DECISION DELEGATED TO HEAD OF PLANNING

Application No: H09-0517-23 **Applicant:** E Andrew Building Contractor

Proposal: Proposed dwelling and garage

Location: Land Between 2 Hall Gate And 76 Church Street Holbeach

1196/01

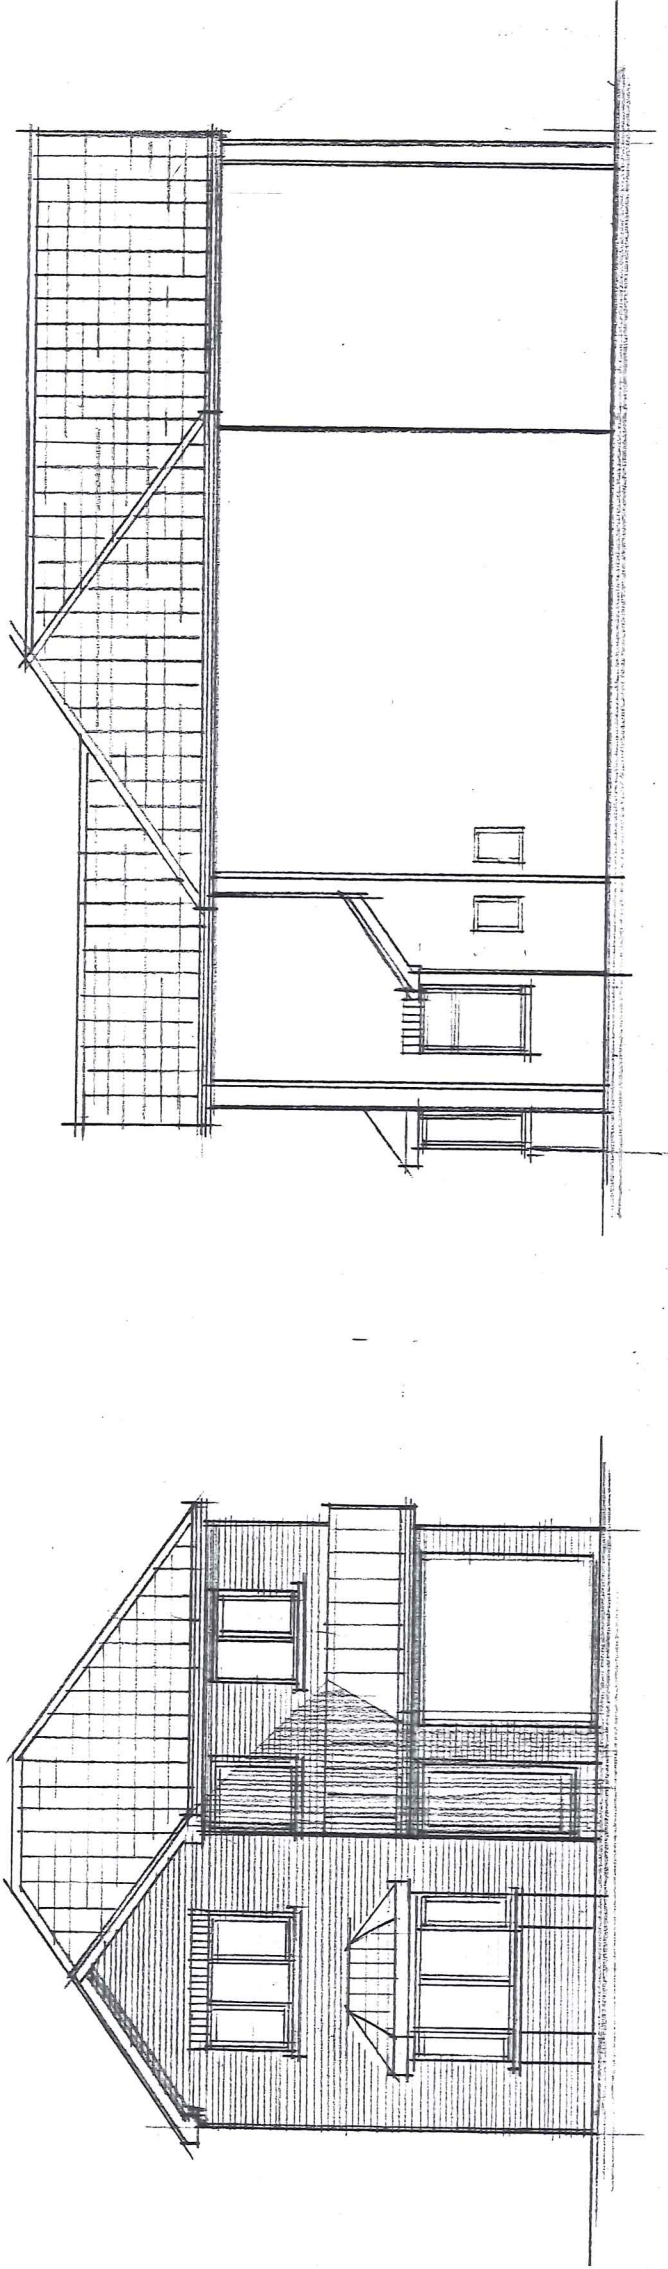
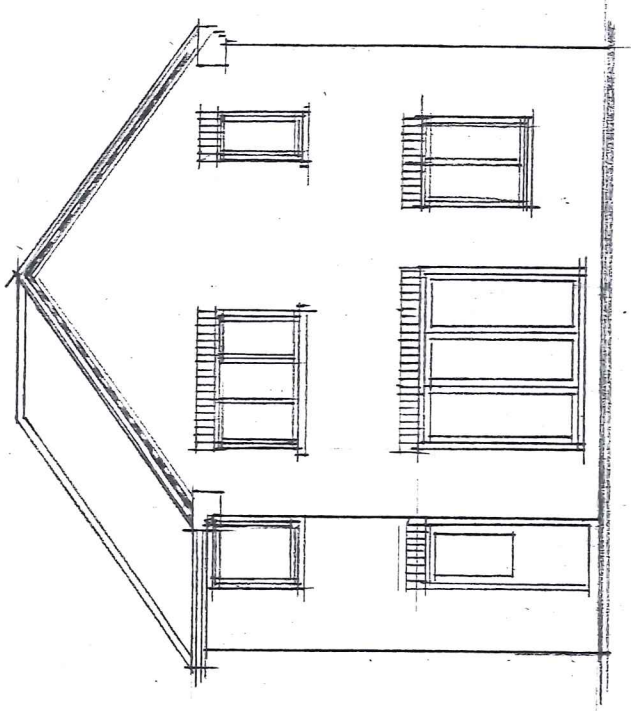
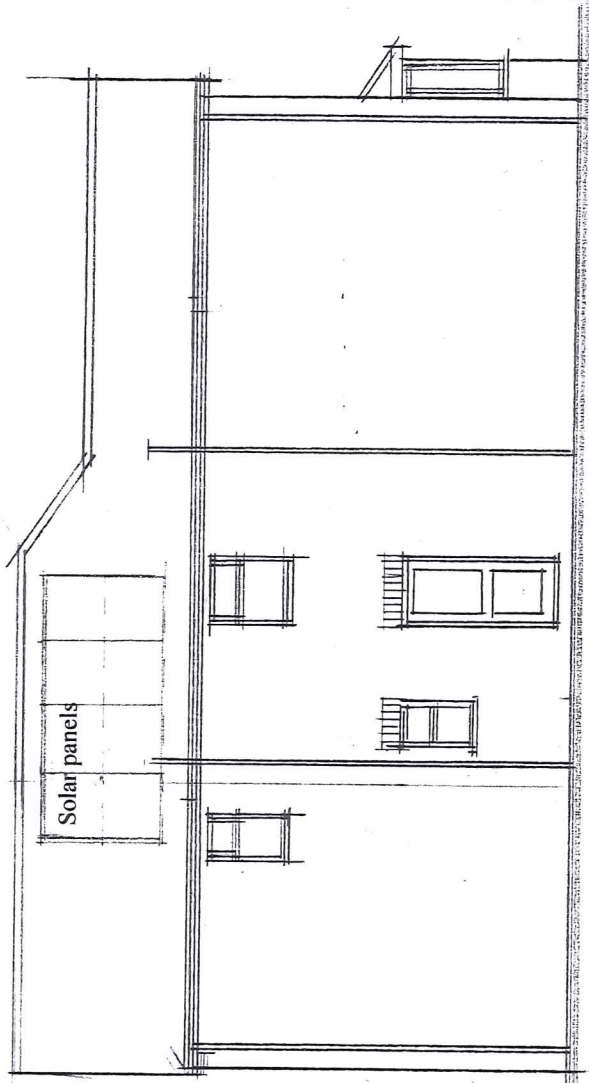
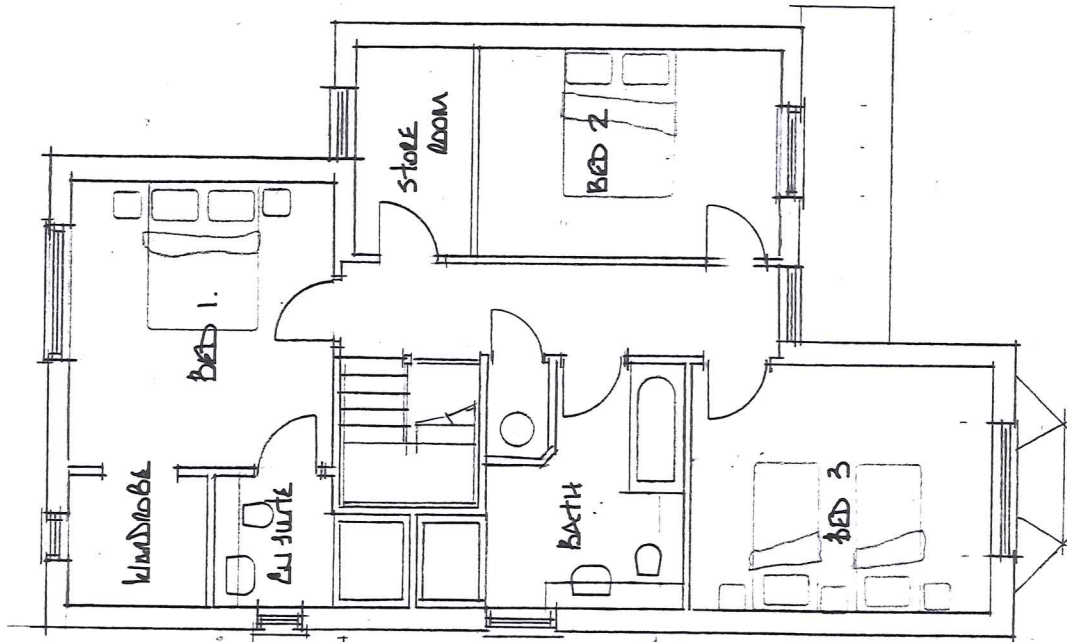
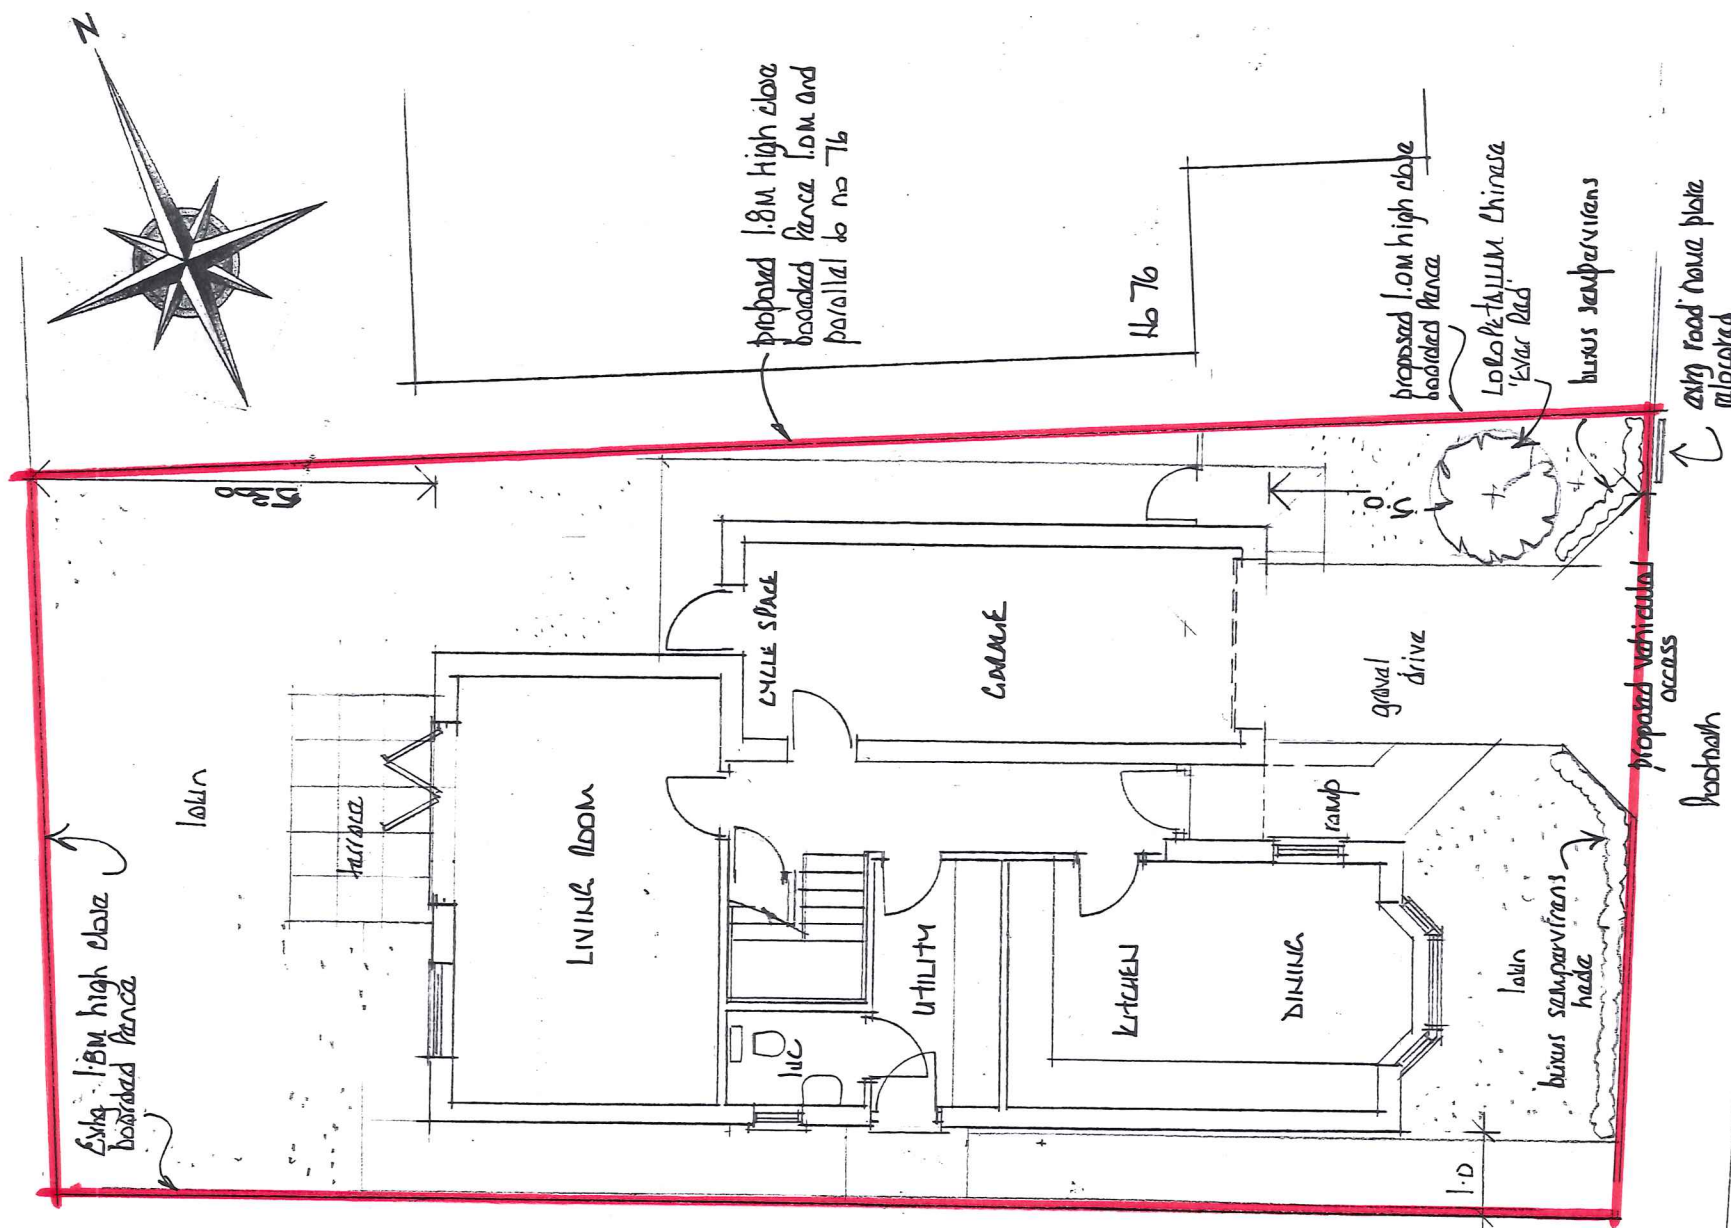
Two first-floor windows are proposed on the southern elevation facing onto 2 Hall Gate. However,

both windows are within bathrooms and will therefore be glazed, reducing the potential for overlooking. Through conditions, the risks posed by these windows may be further controlled. No first-floor windows are proposed on the northern elevation, preventing overlooking onto 76 Church Street. The proposed boundary treatment would sufficiently screen the windows on the ground floor.

There would be three windows within the rear elevation, all of which would face directly onto the garden of 74a Church Street. Due to the limited distances present, the occupiers of the proposed dwelling would have clear views into 74a. This represents a significant overlooking concern.

2 Hall Gate has no windows on its northern elevation, as such, there are no overshadowing concerns with this property. However, there are several windows and a conservatory facing the proposed site within 76 Church Street. While this dwelling is to the north of the site, therefore reducing the potential impacts somewhat, the proximity between dwellings would lead to unacceptable loss of light at 76 Church Street. There is the potential for some overshadowing at 74a, particularly in the morning.

It is considered that the proposal would have an unacceptable amenity impact. Due to the positioning of the windows and conservatory of 76 Church Street, there would be some loss of light. As these rooms are habitable and require a level of sunlight, it is felt that any loss of light would be felt particularly strongly here. It is considered the detrimental impacts here are unacceptable.

Furthermore, it is considered that the proposal would overlook 74a Church Street. This loss of privacy will reduce the quality of life of the occupiers of 74a Church Street. These concerns are reflected in an objection received by the department, stating that the works will produce unacceptable levels of overlooking.
